THE SHOP'S AT MERIDIAN RANCH

FILING NO. 1, LOT 4
 SITE DEVELOPMENT PLAN
 EL PASO COUNTY, COLORADO.
 FALCON, COLORADO

Shop's @ Meridian Ranch
 Site Development Plan
 Stapleton Drive
 Falcon, CO

DRAWING NO.
COVER
 SITE DEVELOPMENT
 PLAN

DRAWING NO.
1
 SITE DEVELOPMENT PLAN

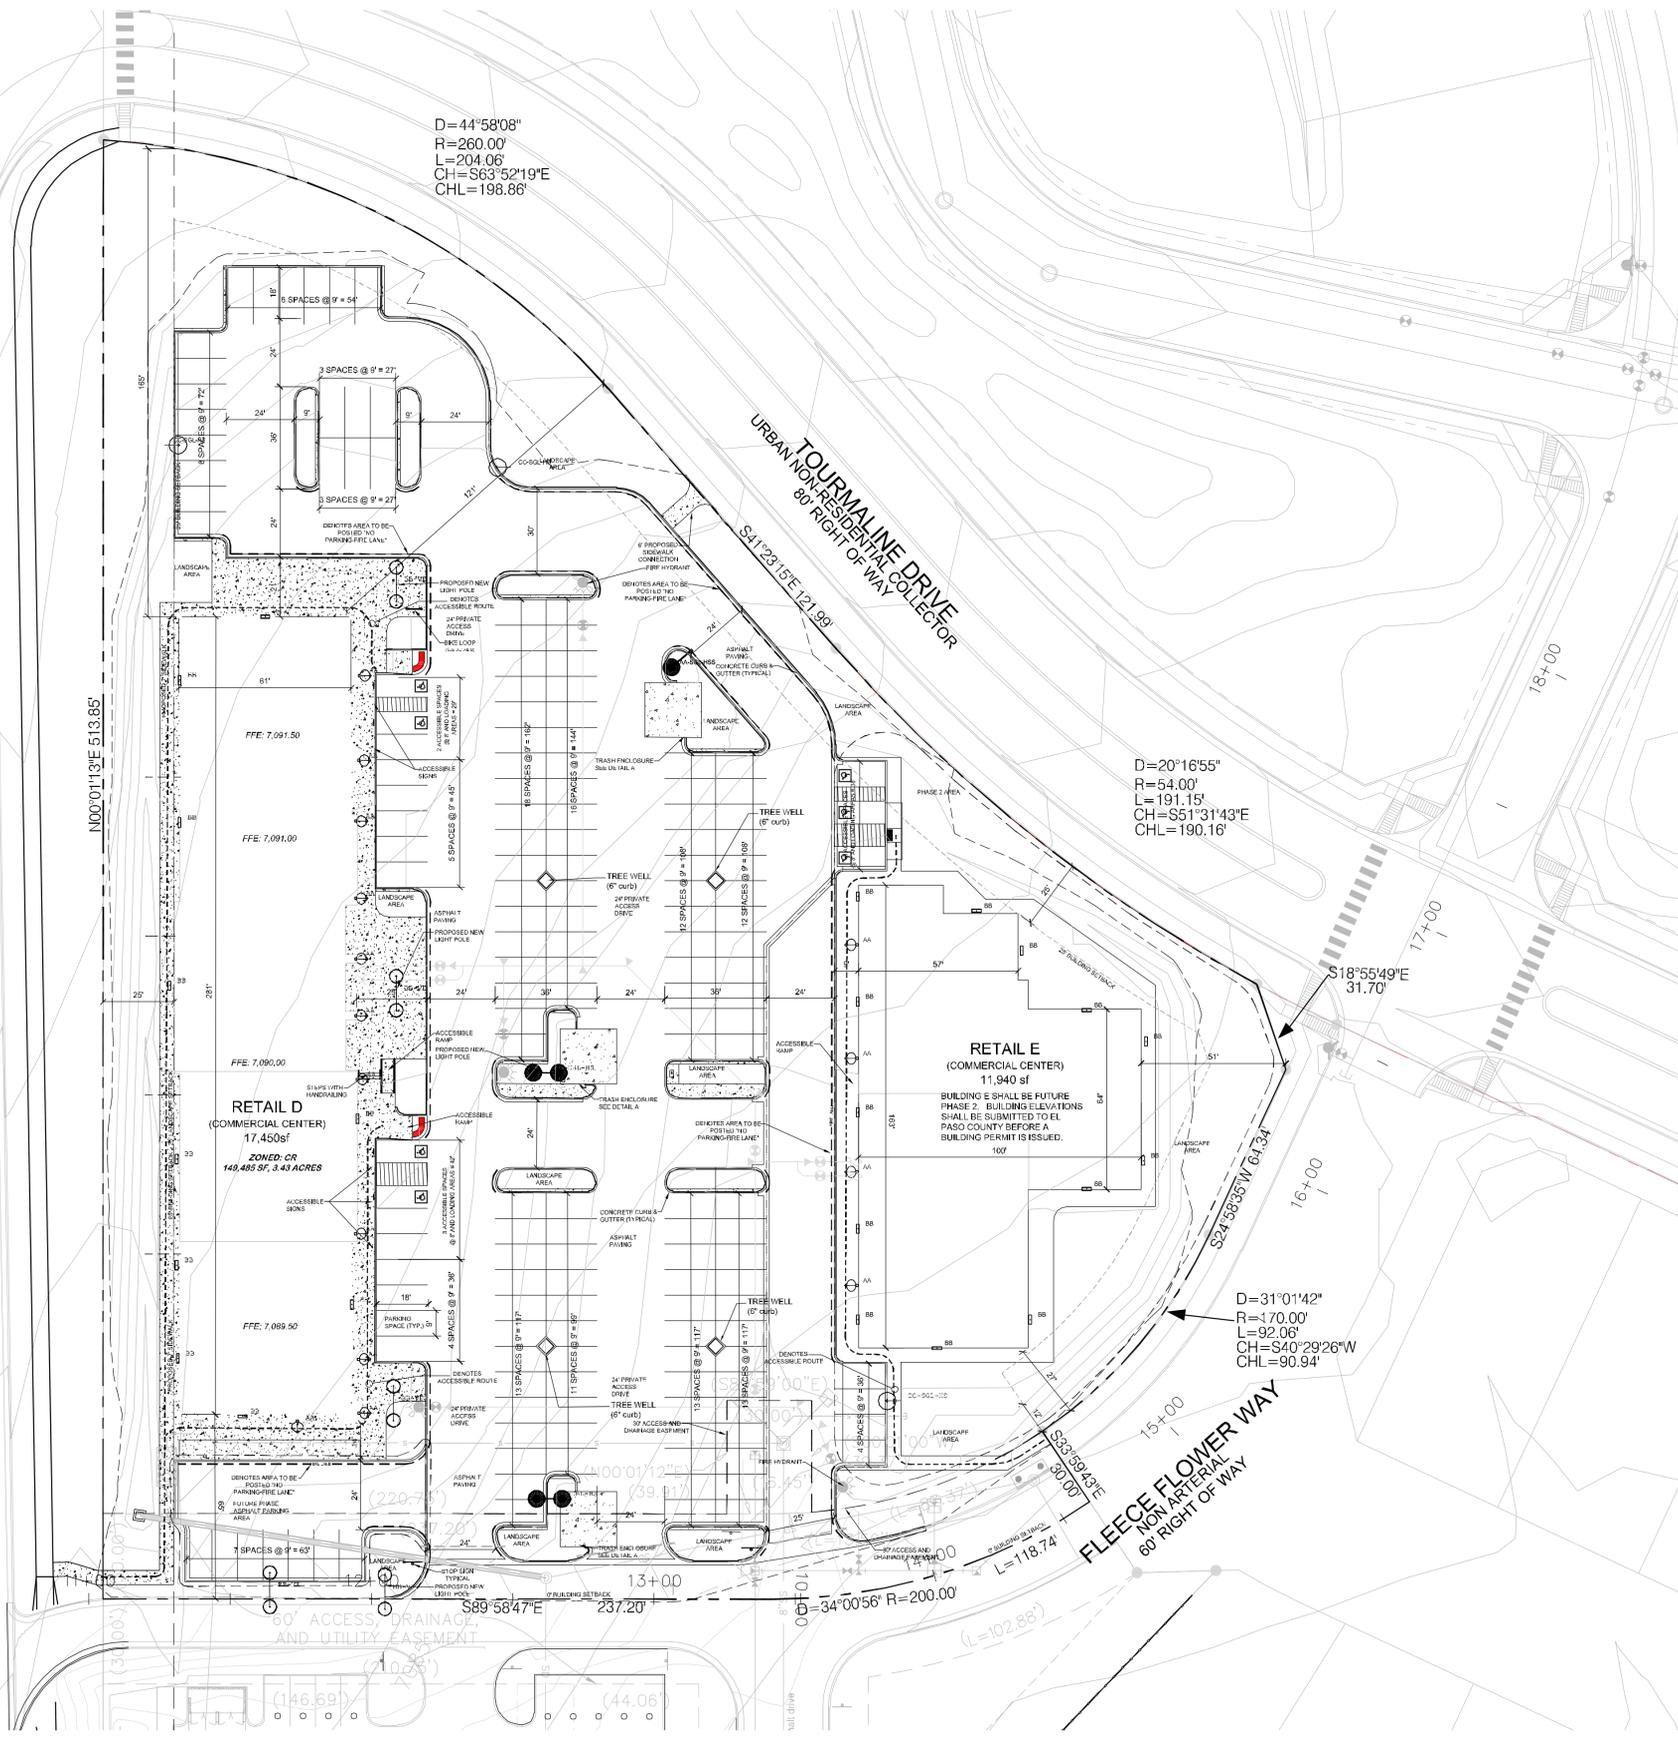
Line up the proposed sidewalk with the existing sidewalk

Tourmaline Drive is classified as an urban non-residential collector

Show setbacks, 50 feet from the front, 25 feet from all other property boundaries, 0 feet if adjacent to CR zoning.

Adjacent to CR zoning - 0 foot setback.

This cannot be 13 feet from the property line. Must be 50 feet.

Side yard setback - 25 feet.

Front Setback - 50 feet

Side yard setback - 25 feet.

The plat identifies this as an access and drainage easement

Show legend of line types for ADA Accessibility route, and property boundaries.

If this structure is not part of this phase, mark it as future expansion. Make sure to take into account the parking layout because this building would not be allowed if proposed as is.
